Appendix A - Response to Submissions Table

1 22 JUNE 9.00AM - EXISTING
1:1000

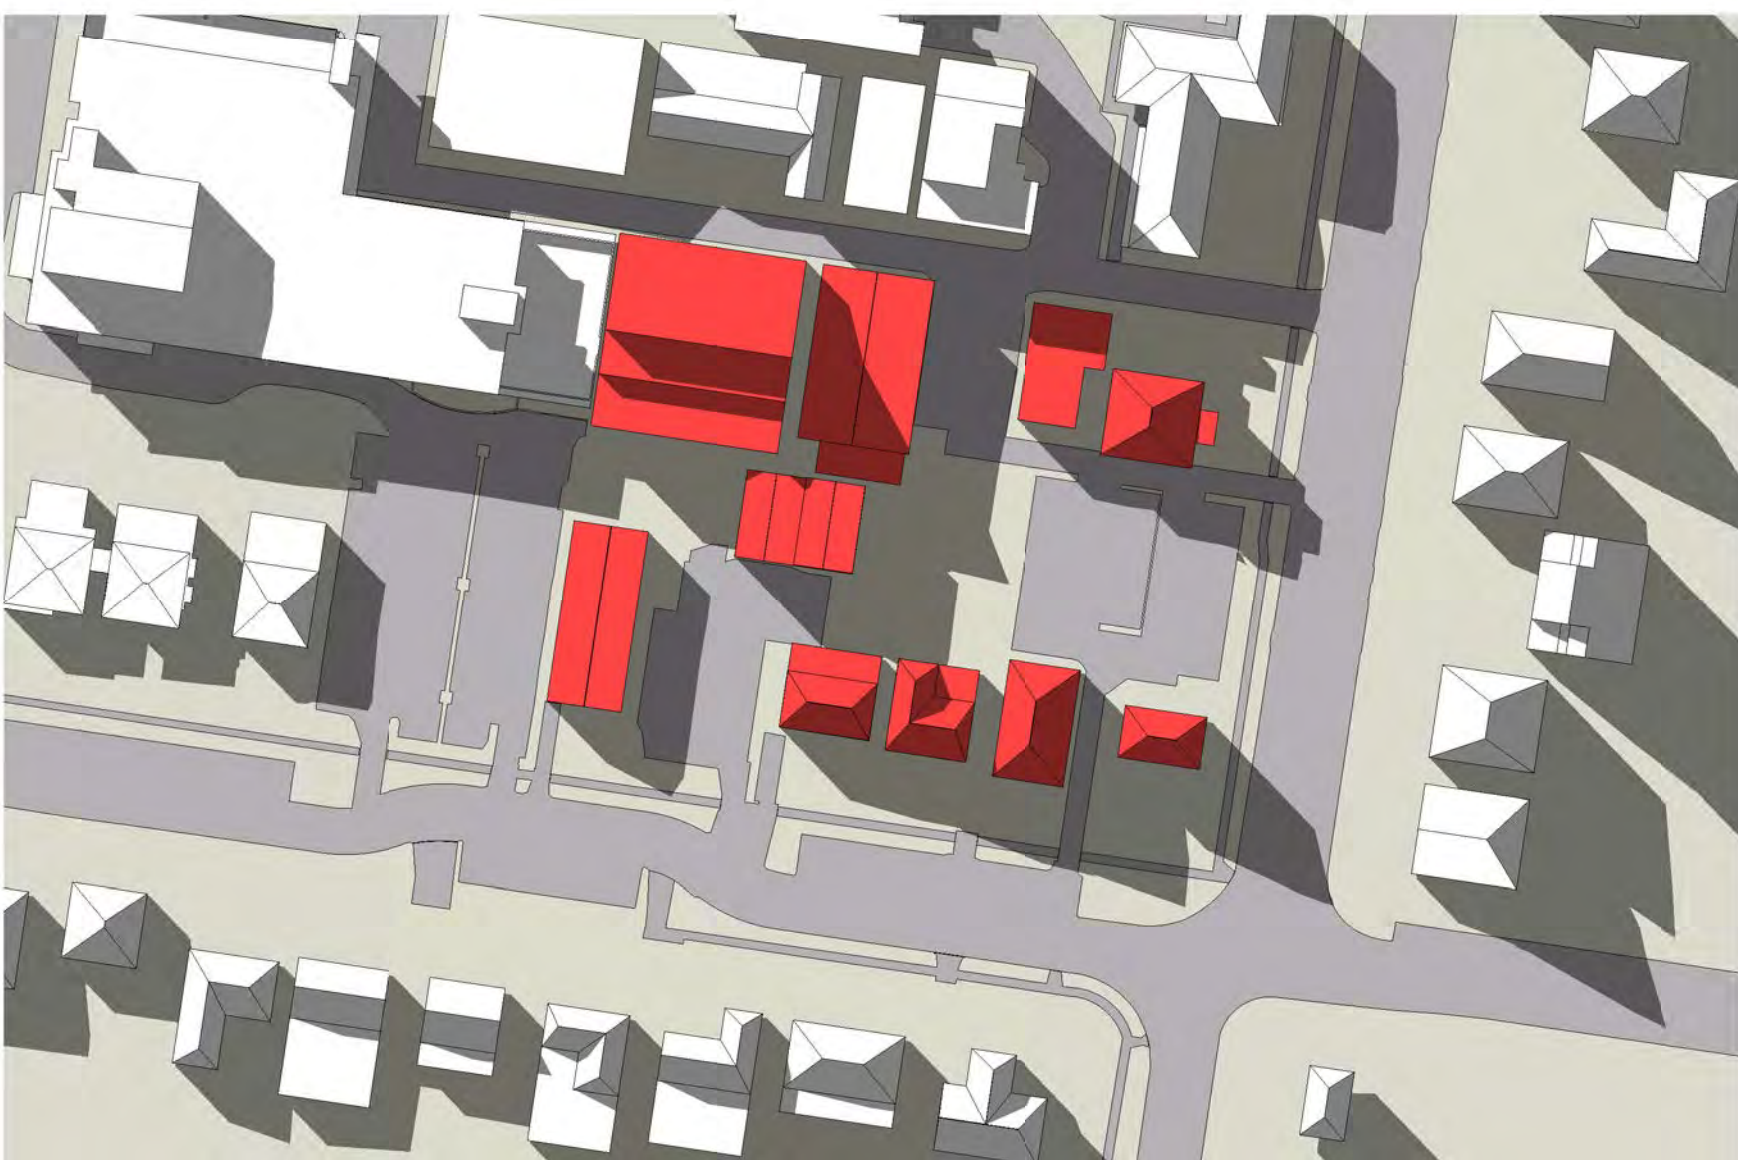
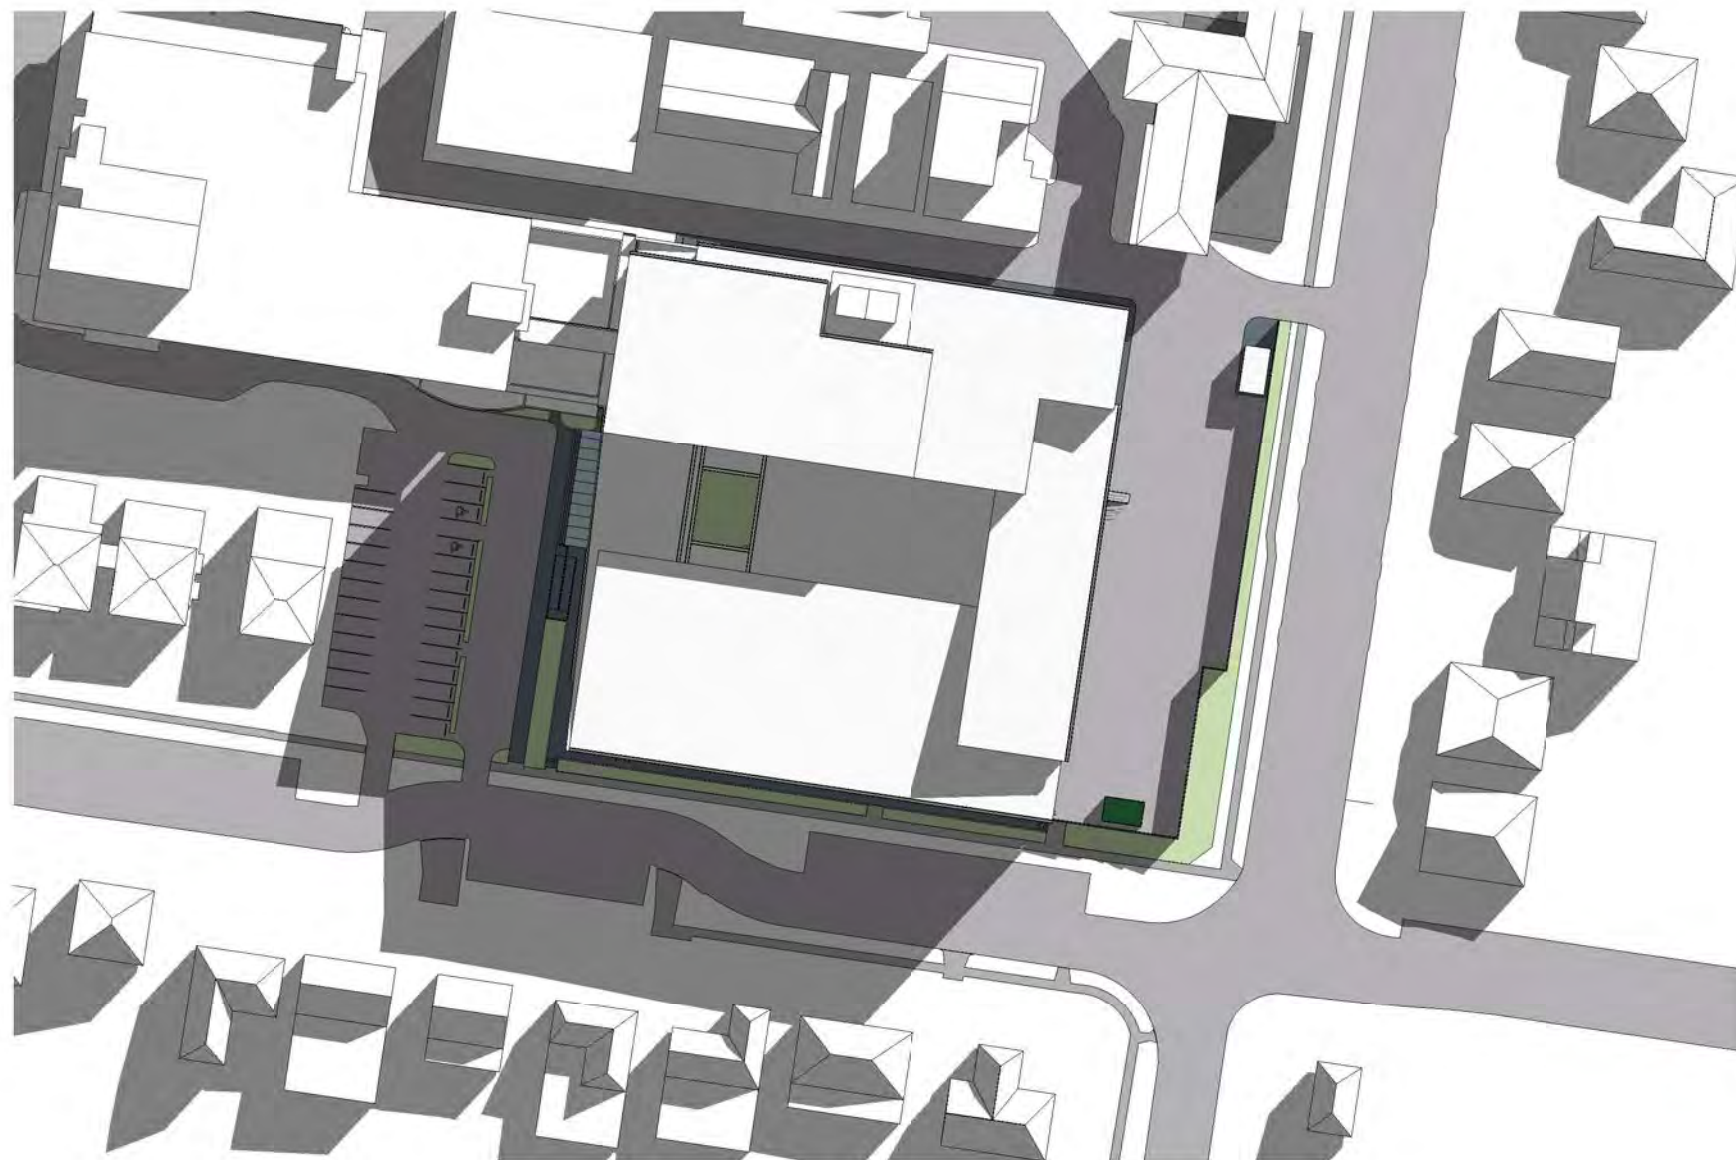
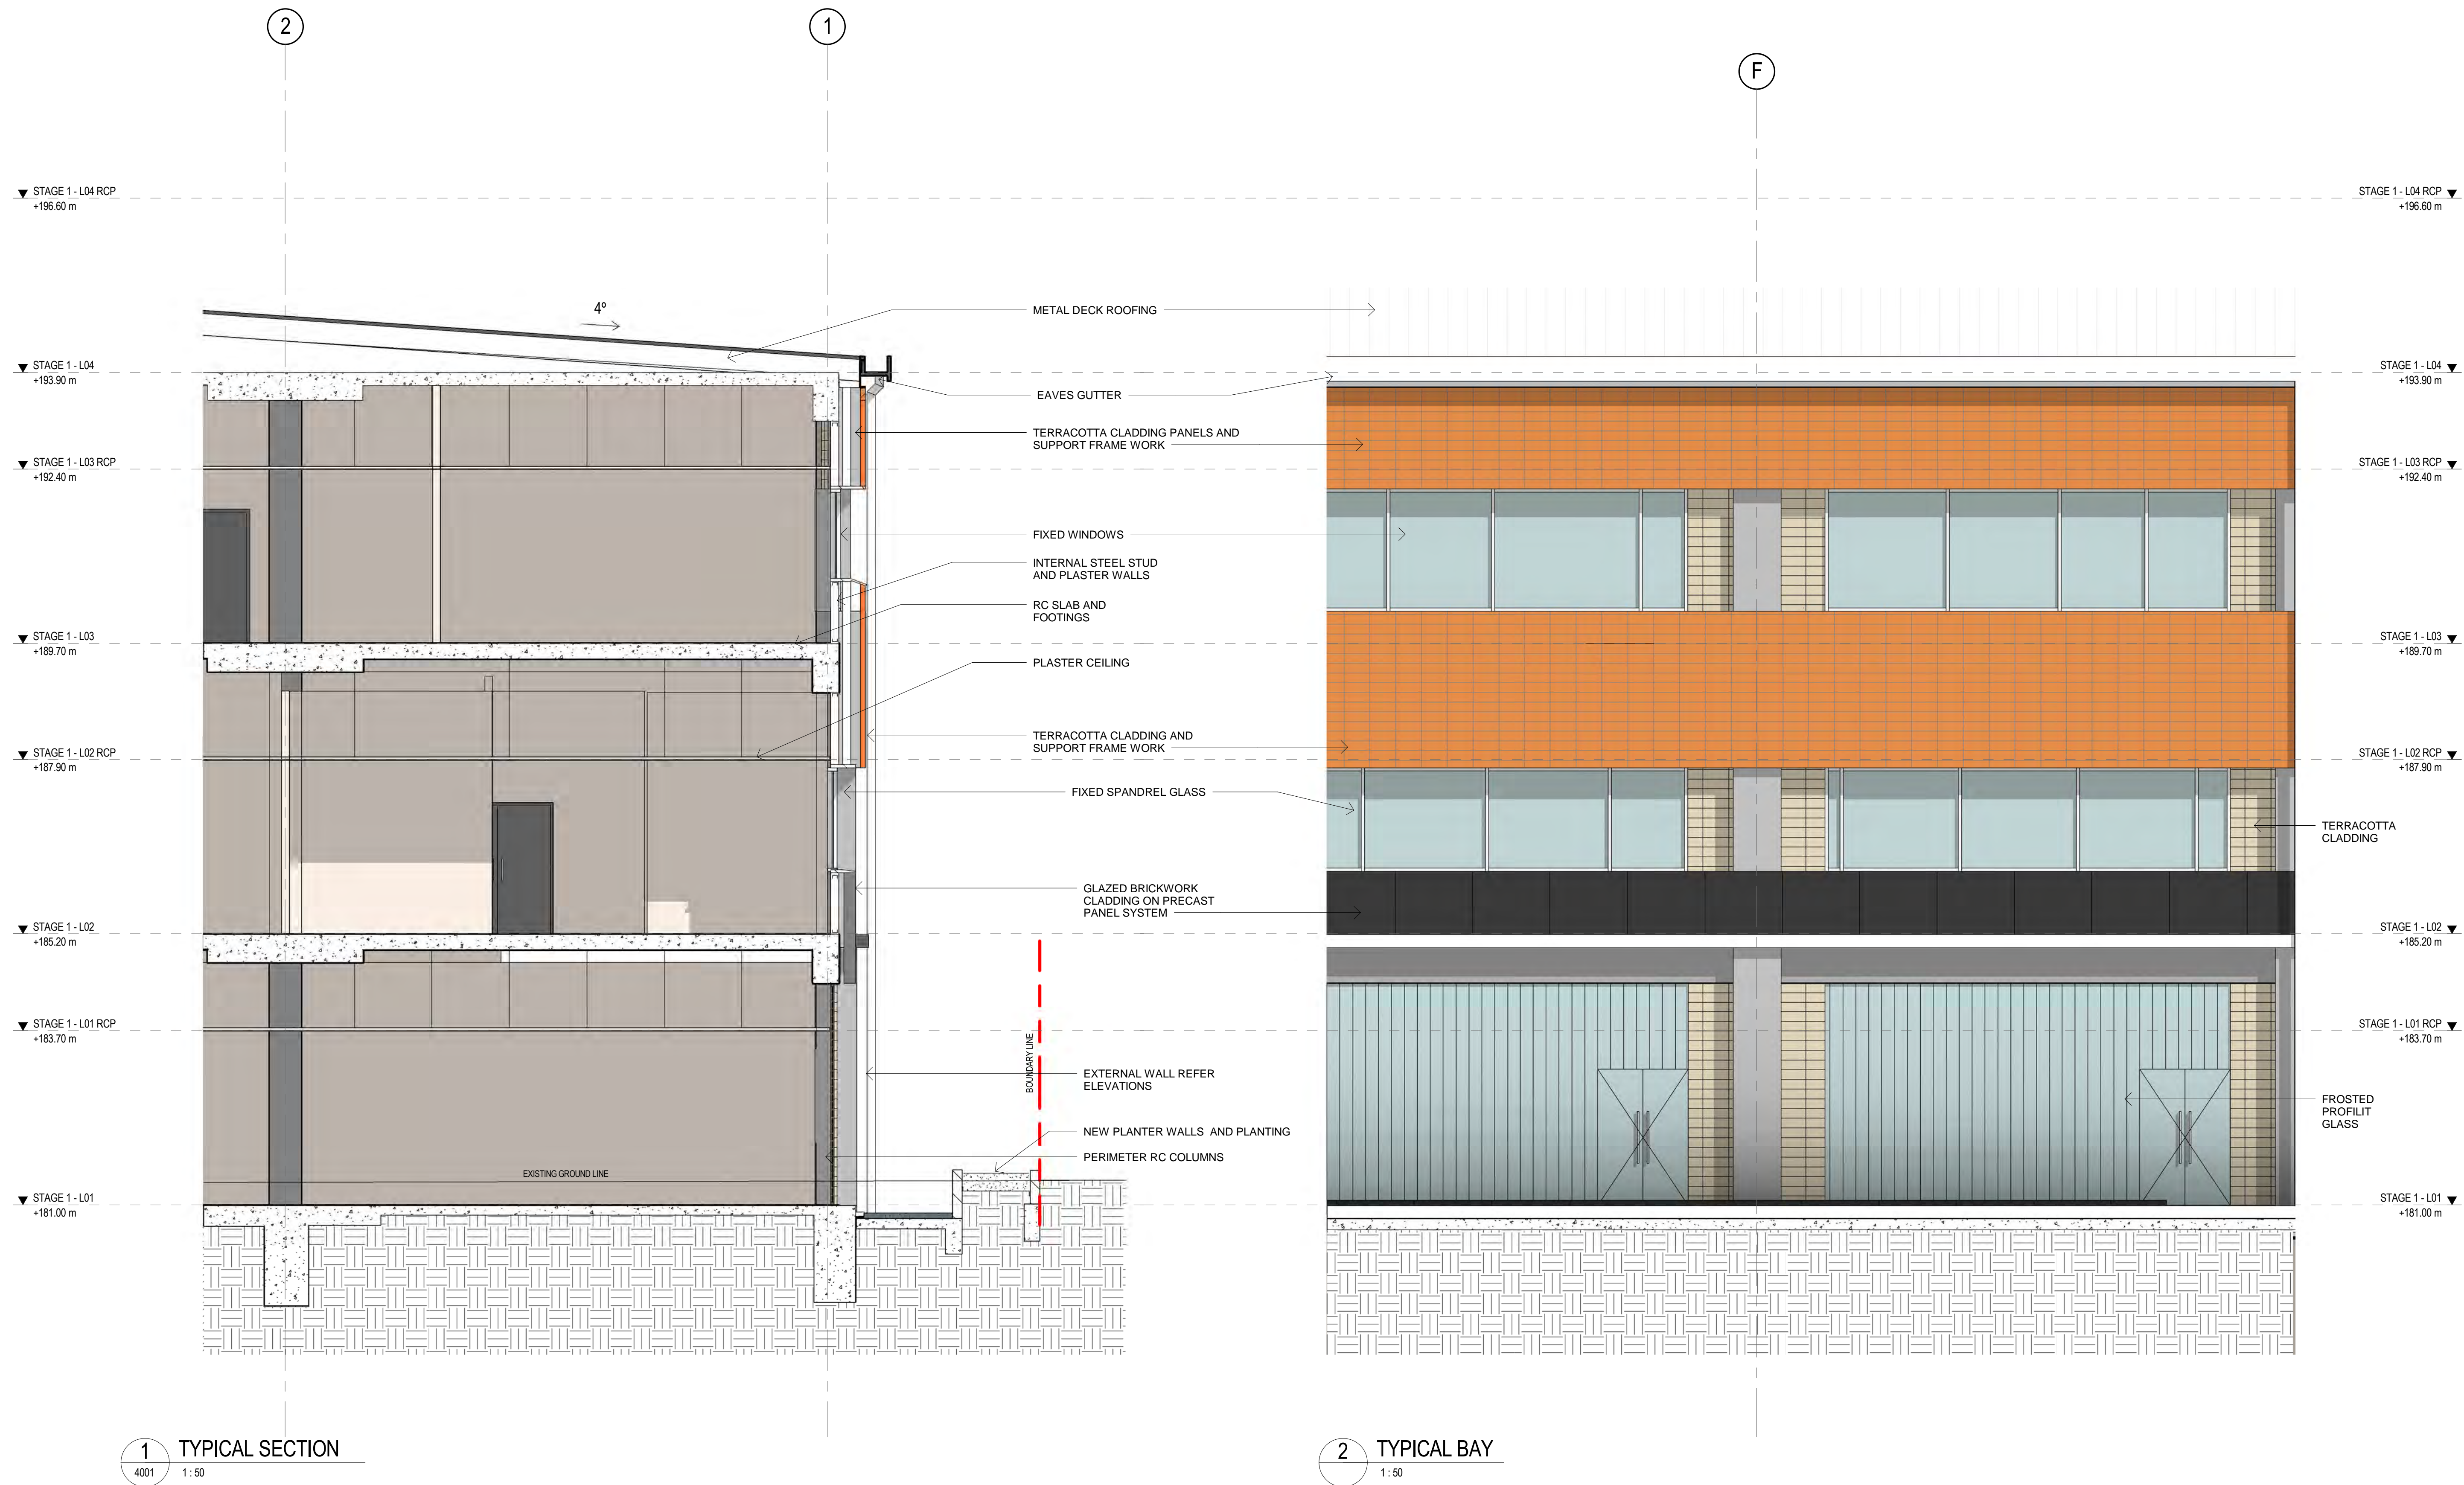
Issues Raised	Proponent's Response
Agency Submissions	
<p>Hornsby Shire Council</p>	<p>Council's concerns in relation to the proposal are as follows:</p> <p><u>Planning</u></p> <p>Hornsby LEP 1994 does not provide a maximum FSR in Special A zone, however Council's Community Uses DCP requires development in Special A zone not to exceed 0.4:1 adjoining low density areas.</p> <p>Council requests that the Department be satisfied the bulk, scale and intensity of development would be compatible with the surrounding low density areas.</p> <hr/> <p><u>Height</u></p> <p>Council requests the Department in its assessment of the proposal has regard to the existing streetscape character to ensure the building would not unreasonably restrict sunlight or result in loss of privacy and amenity to adjacent residential properties.</p>

Issues Raised	Proponent's Response
	<p>windows to principal internal daytime living spaces between 9am and 3pm.</p> <p>The addition of vegetation within the setback will (when mature) provide further privacy screening and softening buffering. Further, as described in Section 2.2 of the Response to Submission Report, the proposed development's envelope and scale is appropriate in relation to the width of Burdett Street. Figure 3 of the Response to Submission Report demonstrates the containment of the building wholly within the sightline of 45° when an individual is viewing the development from the opposite side of Burdett Street. The proposal is therefore not considered to be overbearing and bulky from street level and is appropriate in its context and relative to the lack of height controls governing development of the site.</p>
<p><u>Setback and Landscape</u></p> <p>The building setback to Burdett Street should be increased to enable additional landscaping within the site between the building and the property boundary along the frontage.</p> <p>There is limited articulation of the building façade and the setback should be consistent with the existing established streetscape.</p> <p>Small trees should be provided in the additional landscape area between building and property boundary.</p>	<p>The landscape setback to Burdett Street has been increased by reducing the width of the maintenance path that runs along the southern boundary of the building. This allows for additional planting between the property boundary along the Burdett Street frontage.</p> <p>There are no site-specific provisions for setbacks within Hornsby Shire Council's controls. Therefore the setback has been considered on its merits and is considered suitable for the scale of the proposed building, consistent with the existing hospital development.</p> <p>As detailed in Section 2.2 of the Response to Submission Report, the Stage 1 footprint has been located to provide for optimal functional adjacency and connectivity to the HOPE building and to minimise disruption to ongoing hospital-related activities and to provide for the best continuity of services to the community. Its location also allows for only minimal removal of vegetation and takes advantage of existing driveway crossings. Furthermore, and most importantly, the floor plate is designed to deliver optimal functional and efficient health services. There is no flexibility for the building to</p>
